# Gatwick Airport Northern Runway Project

## Air Quality Technical Queries

Application Document Ref: 10.83

PINS Reference Number: TR020005

Appendix A: Gatwick NRP Temporary Compounds and Construction Vehicle (HGV) Access Routes

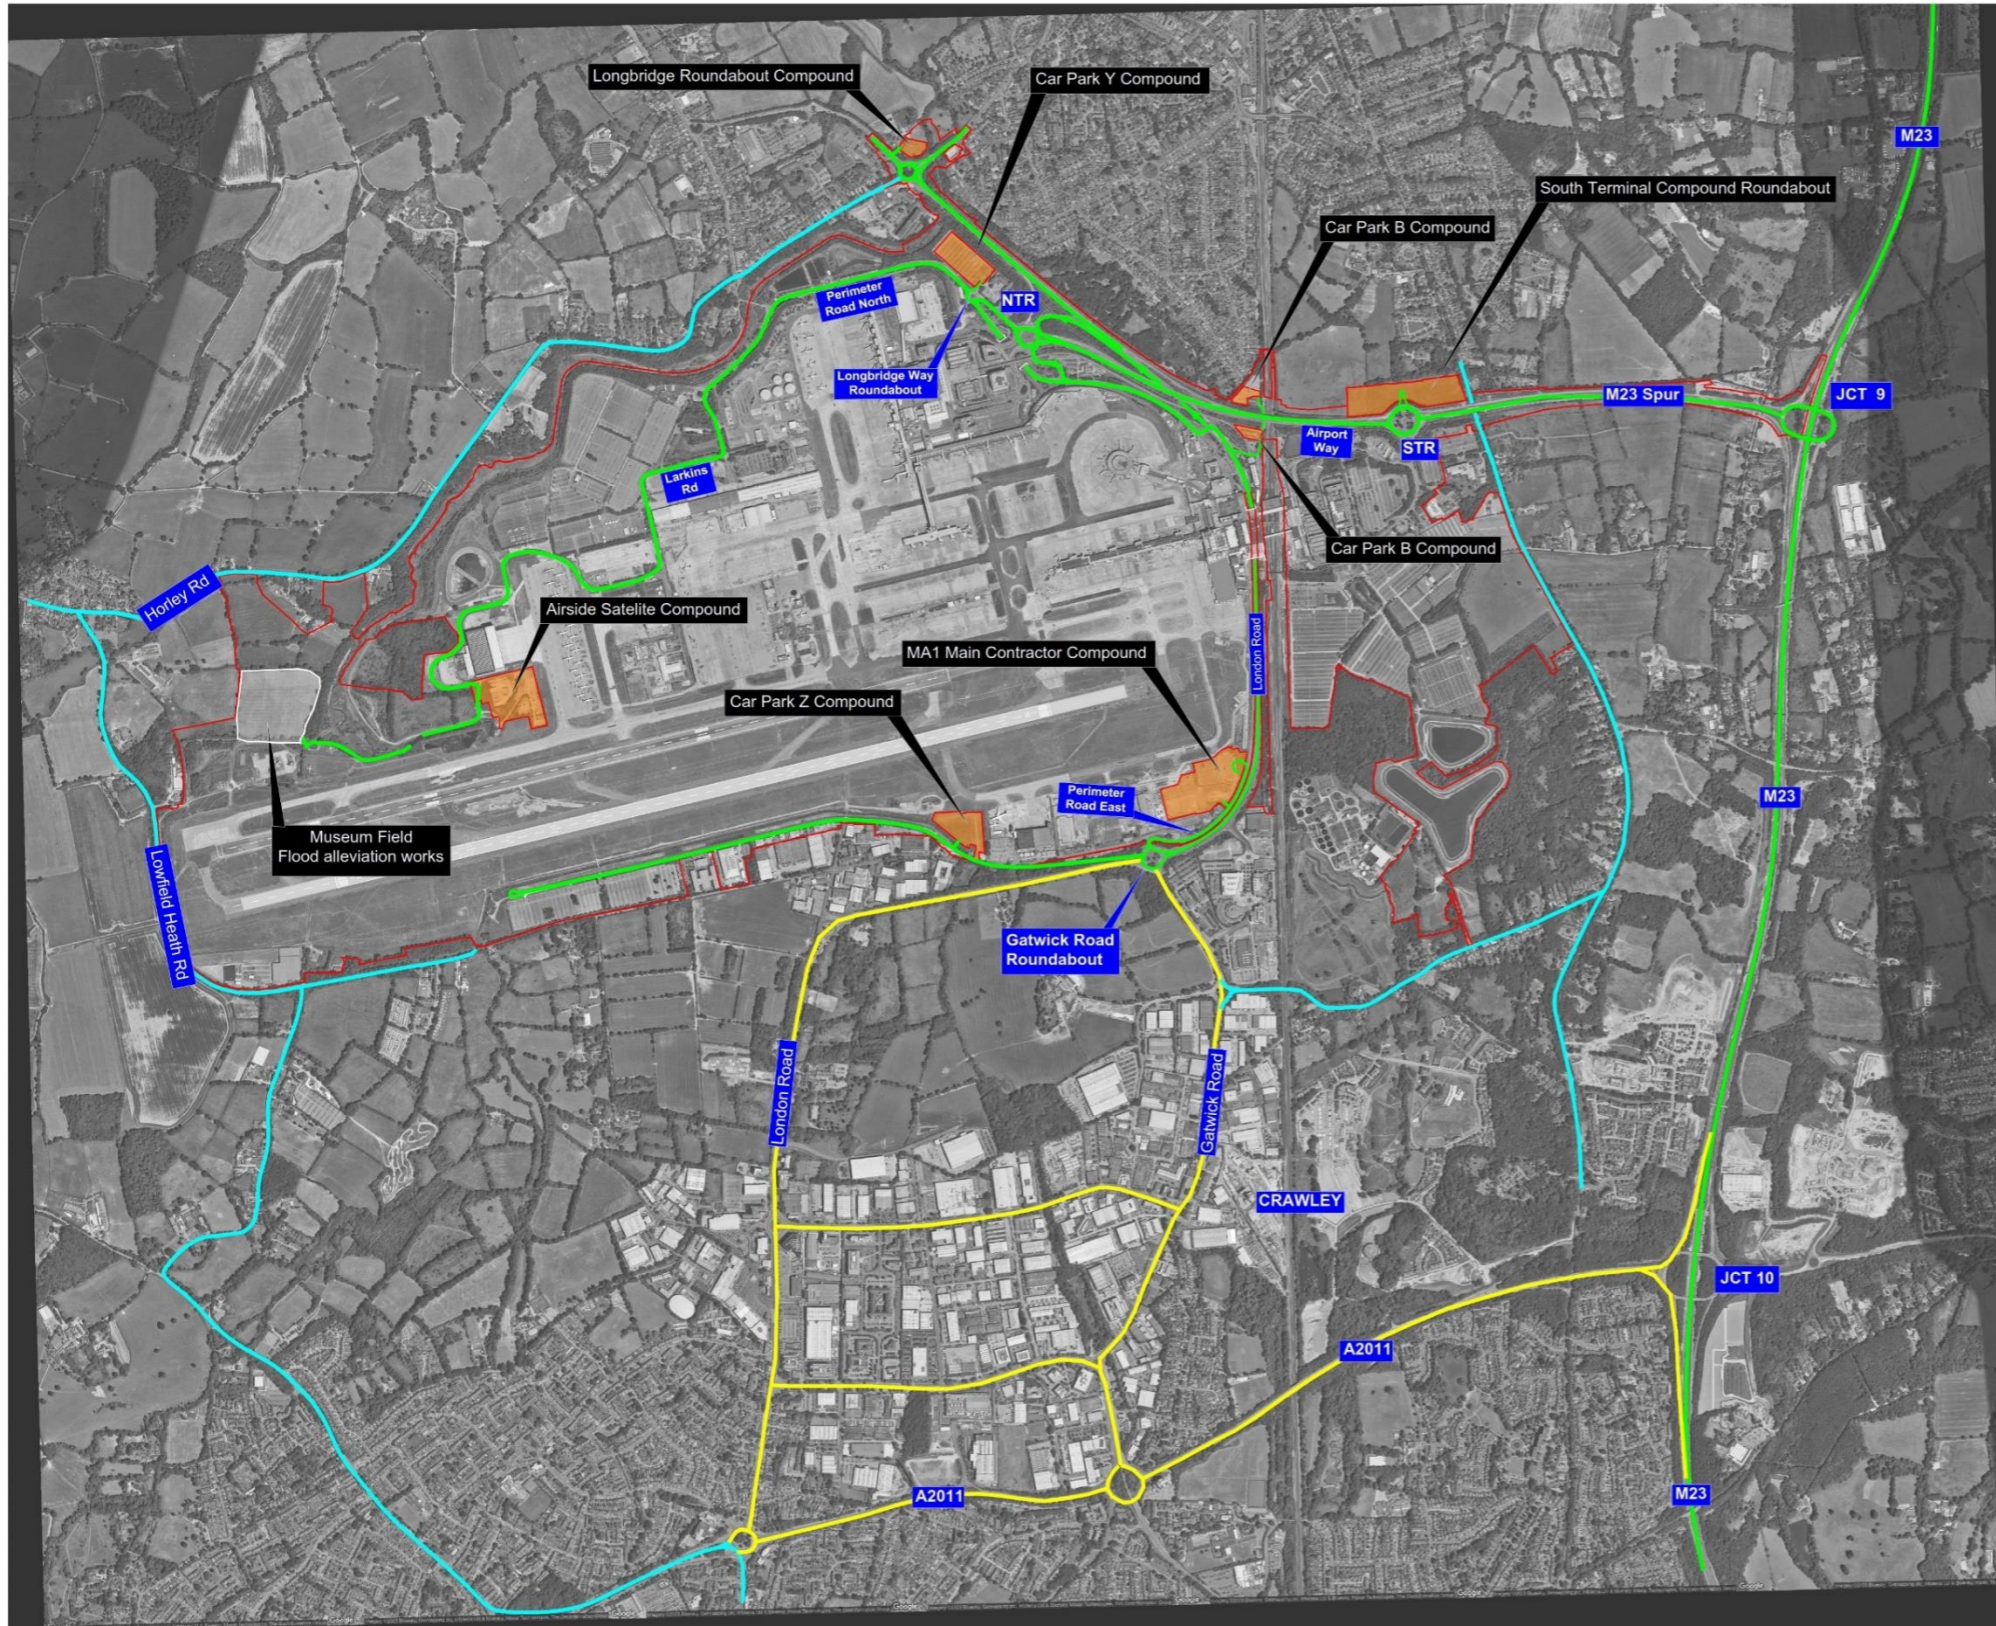
A.34	No further information has been provided by the Applicant to explain the level of likely use of the contingency access. Further information is still required on the use and monitoring of this contingency route. Sanctions may also be needed to ensure that this route is not used excessively.	<p>Monitoring requirements are set out in section 6.6 of the oCTMP [REP7-026] and section 10 of the oCWTP [REP7-024]. Further detail will be provided in the CTMP and CWTP submitted to local authorities for approval under DCO Requirements 12 and 13 respectively.</p> <p>Section 6.6 of the oCTMP [REP7-026] has been updated to provide more certainty in relation to Junction 10 M23 and Hazelwick Air Quality Management Area.</p>
A.35	The response appears to indicate that a very basic review of monitoring data to check whether air quality is exceeding air quality standards along would be used. Rather than a monitoring system with different thresholds below the air quality standards to determine when a risk of exceedance is emerging to allow action to be taken ahead of any exceedance. The local authorities concerns about how the Applicants "Restrictions and Monitoring" within the CTMP would identify, monitor and control construction traffic utilising routes through the J10 M23 and Crawley's AQMA.	Section 6.6 of the oCTMP [REP7-026] has been updated to provide more certainty in relation to Junction 10 M23 and Hazelwick Air Quality Management Area. Further detail will be provided in the CTMP submitted to local authorities for approval under DCO Requirement 12.
